Application no: **3/2021/0731**

Address: **St James C of E Primary School Greenacre Street Clitheroe BB7 1ED**

The Local Highway Authority have viewed the plans and highway related documents and have the following comments to make:

The LHA previously responded to the application on 11th August 2021, requesting the Applicant to submit further information regarding the proposed secondary access due to the proposal conflicting with a variety of existing street furniture and apparatus. As a result, the Applicant has submitted Cassidy + Ashton drawing number P01 Rev A titled "Proposed Site Plan," and so the revised plan is reviewed below.

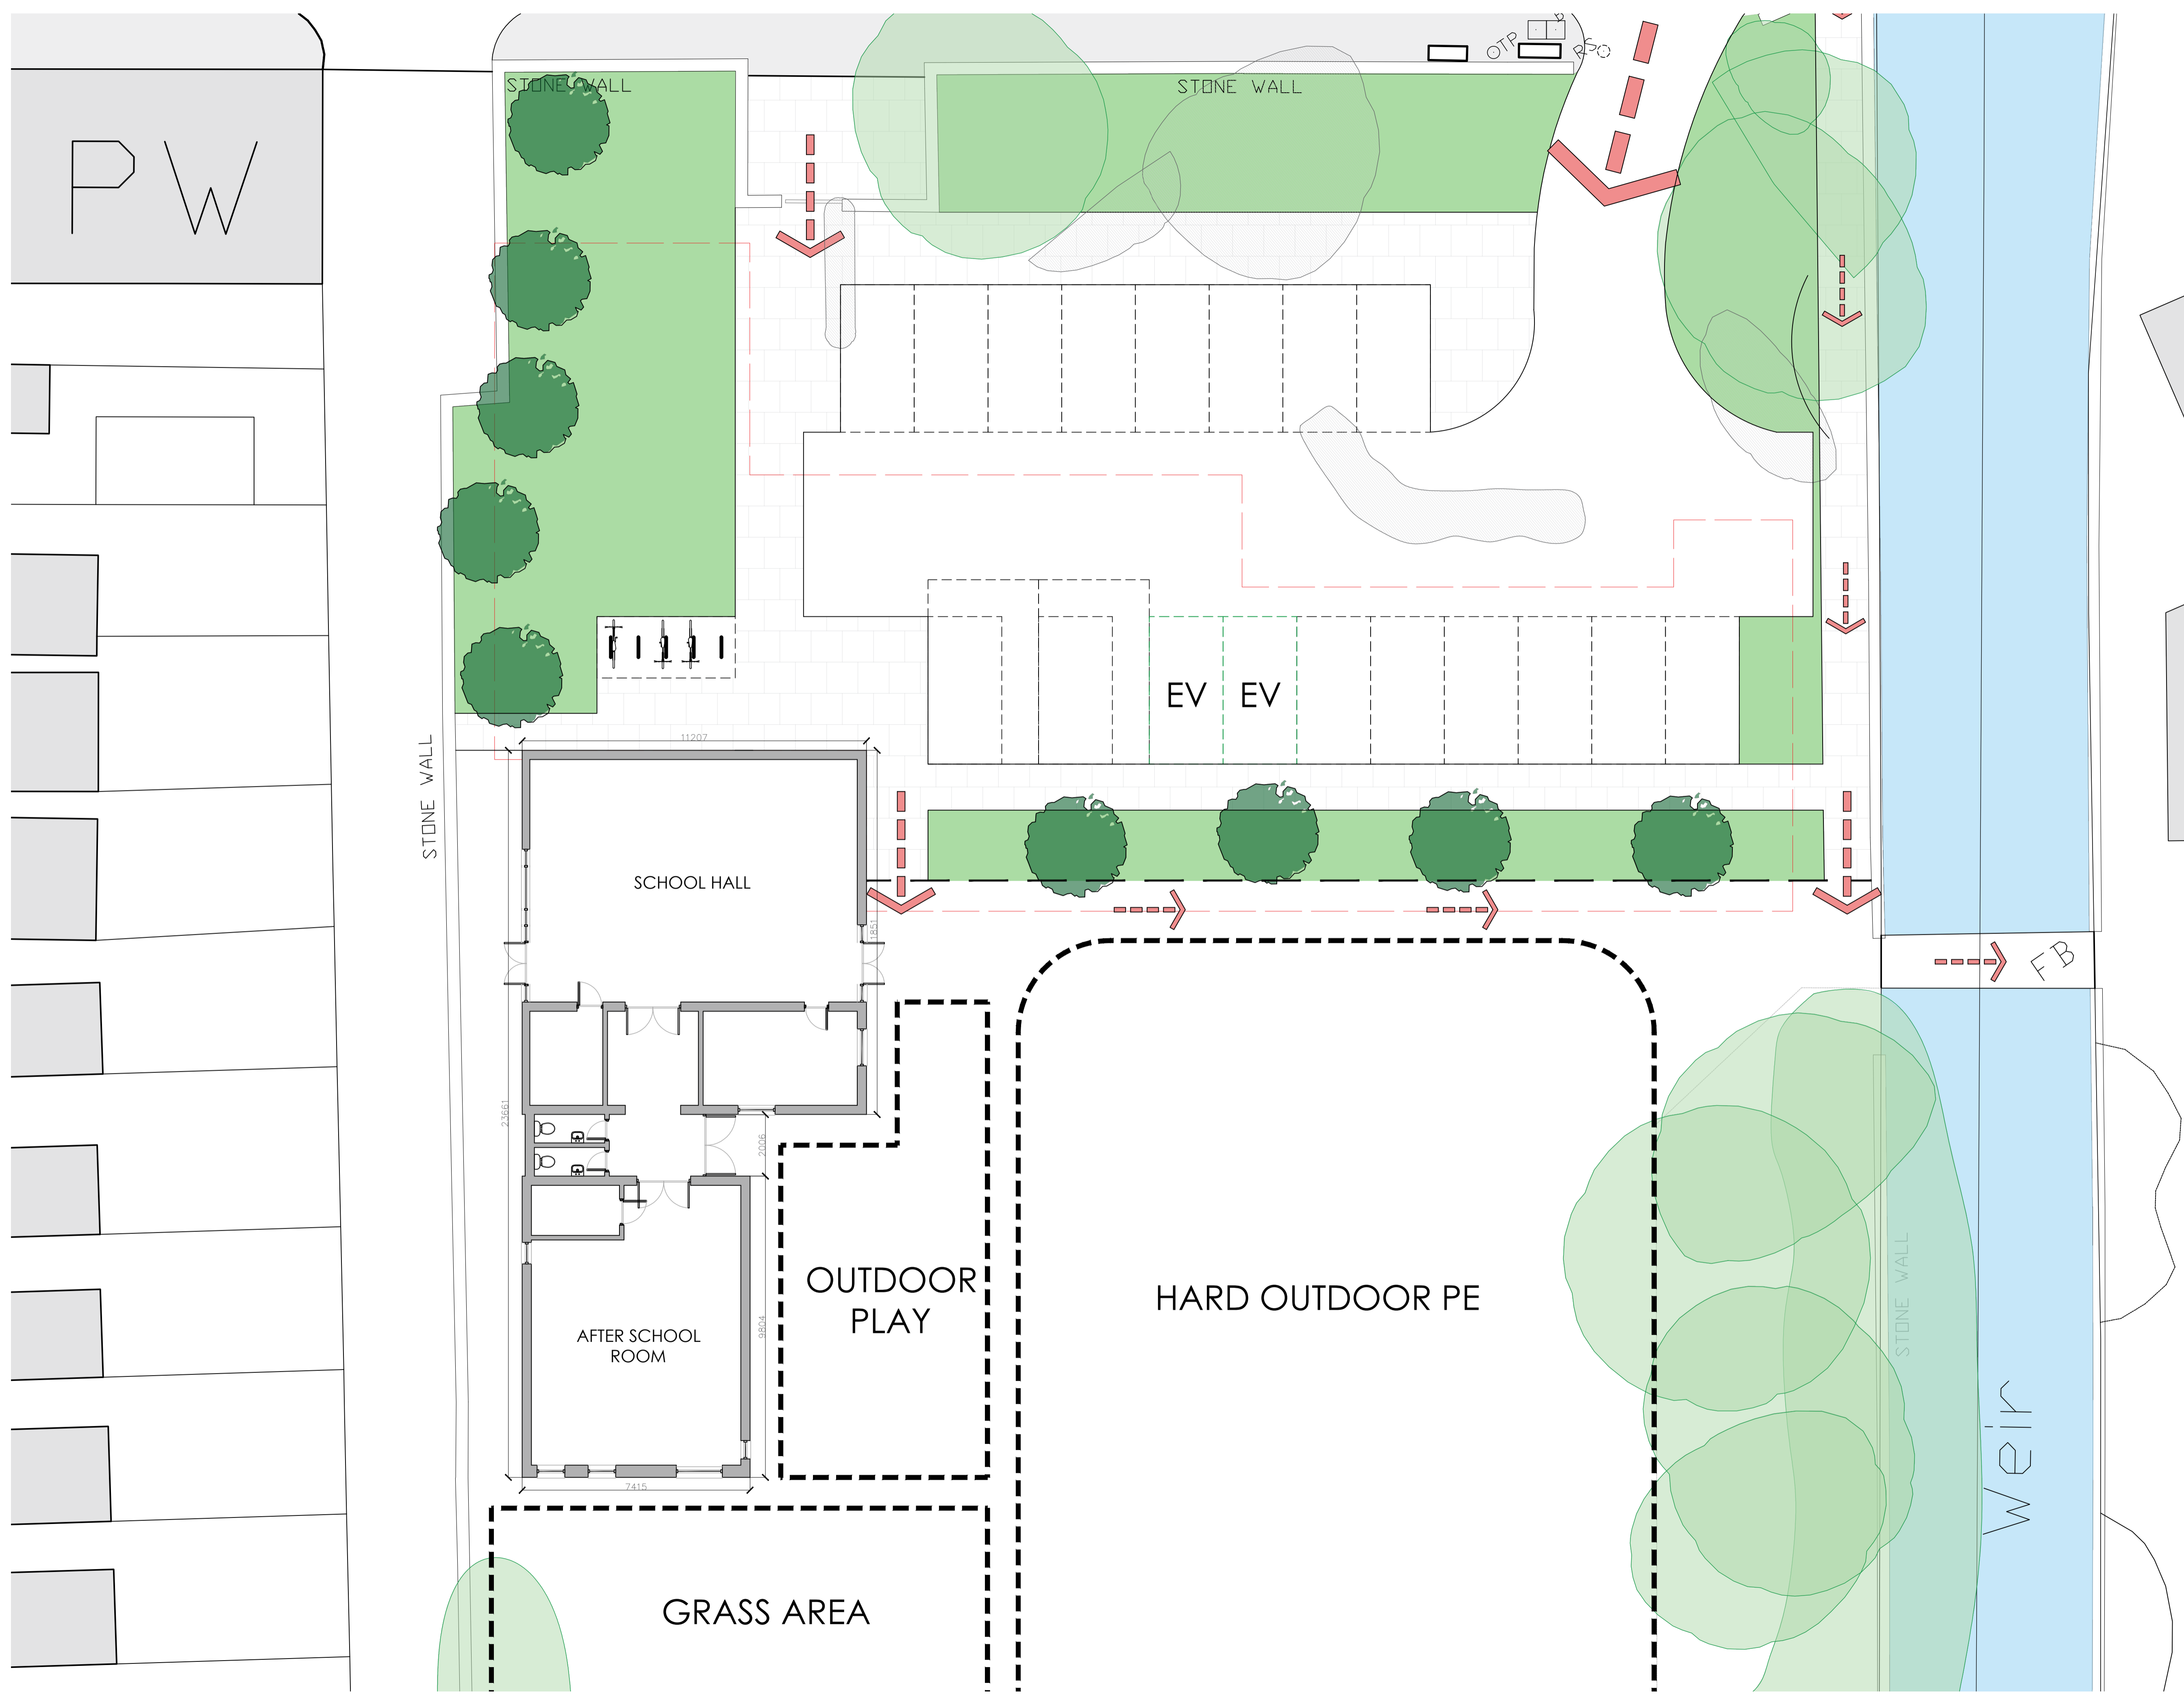
The LHA have reviewed Cassidy + Ashton drawing number P01 Rev A titled "Proposed Site Plan," and understands that the site will have two accesses following the proposal.

The first access, which is currently the existing, will be widened from 3.2m to 4.2m. For a primary school access to comply with the LHAs guidance, the access is normally required to be a minimum of 6m wide.

However, in this case, as stated in the previous highway comments dated 11th August 2021, the LHA will accept the shortfall due to the access already being existing and the Applicant proposing to widen the access to make it safer and suitable for its use.

Furthermore, the LHA have reviewed the drawing and understands that the secondary access will be approximately 6.4m wide which complies with the LHAs guidance.

On the revised drawing, as the LHA suggested in the previous highway comments, the Agent has shown all of the street furniture and apparatus which could potentially conflict with the proposed access. The LHA have reviewed the drawing and understands that the "One-way" street sign will need to be relocated following the proposal due to the access conflicting with it.

The sign will need to be relocated next to the telegraph pole, should there being adequate space, to allow for vehicles exiting the Holmes Mill junction to clearly view and understand that Greenacre Street is a one-way street. Not only this but the sign is currently illuminated, powered by electricity and so the electricity supply will also need to be disconnected before the relocation. This will be at the expense of the Applicant and can be all agreed following the completion of the Section 278 agreement.

It is also noting that should the access conflict with any of the other street furniture then the Applicant will also be liable to the full cost of relocating them further along the street, if at all possible.

The LHA have reviewed Cassidy + Ashton drawing number P01 Rev A titled "Proposed Site Plan" and understands the site will provide 26 car parking spaces for the proposal, including 2 disabled spaces. This complies with the Joint Lancashire Structure Plan which requires a Primary School to provide a car parking space per classroom or activity area. Therefore, the LHA have no further comments to make.

1. No part of the development hereby permitted shall be occupied until such time as the access arrangements shown on Cassidy + Ashton drawing number P01 Rev A have been implemented in full.

2. No part of the development hereby permitted shall be occupied until such time as vehicular visibility splays of 2.4 metres by 25 metres have been provided to the right of both site accesses. These shall thereafter be permanently maintained with nothing within those splays higher than 1 metres above the level of the adjacent footway/verge/highway.

3. No part of the development hereby permitted shall be occupied until such time as 2.0 metre by 2.0 metre pedestrian visibility splays have been provided on the highway boundary on both sides of the access with nothing within those splays higher than 1 metres above the level of the adjacent footway/verge/highway and, once provided, shall be so maintained in perpetuity.

5. The development hereby permitted shall not be occupied until such time as the parking and turning facilities have been implemented in accordance with Cassidy + Ashton drawing number P01 Rev A. Thereafter the onsite parking provision shall be so maintained in perpetuity.
